Subject: 2023/91474 - 94 New North Road

Writing on behalf of Huddersfield civic society.

Proposed Plans and Elevations

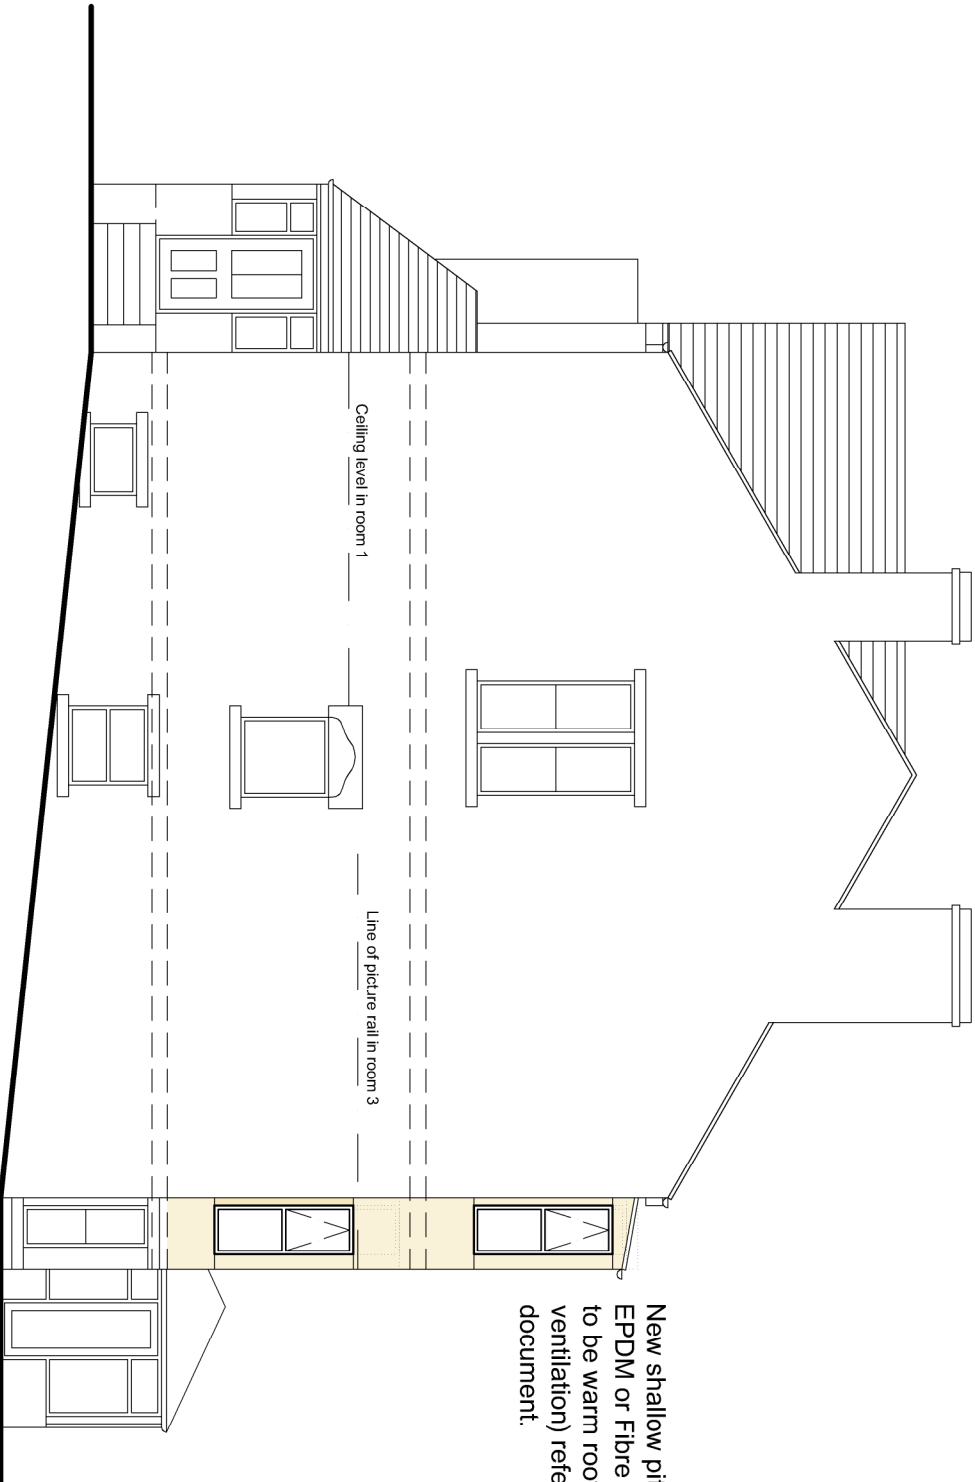
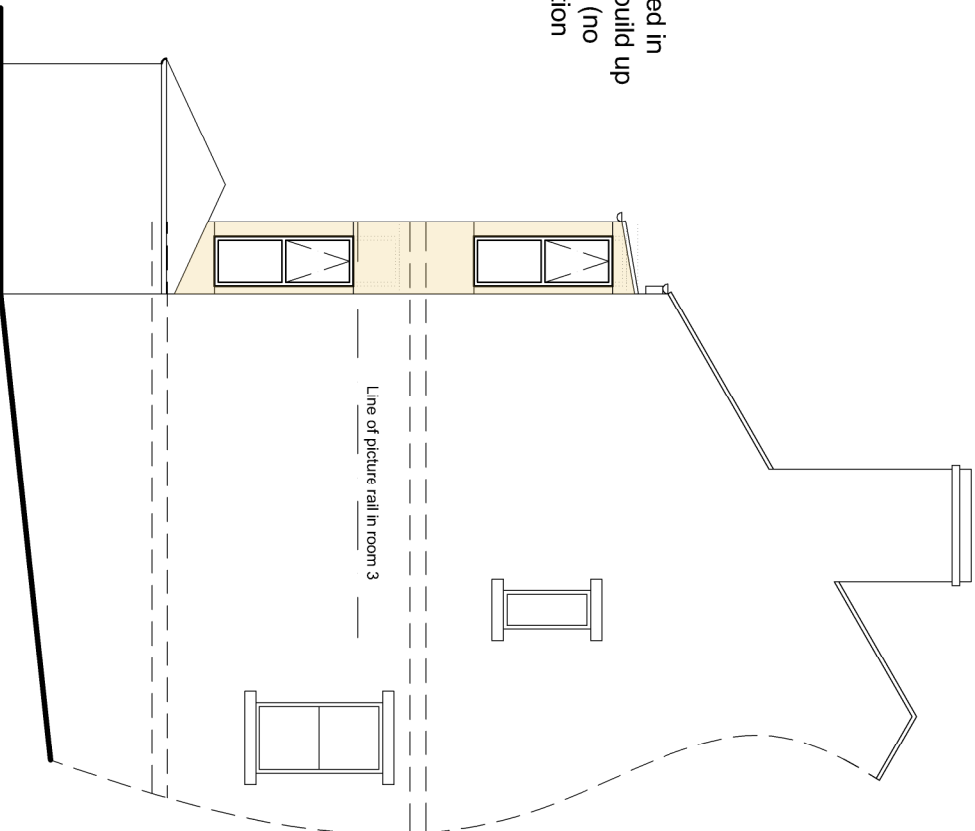
The owner wants to remove the chimney stack and make various small, but totally inappropriate, other changes.
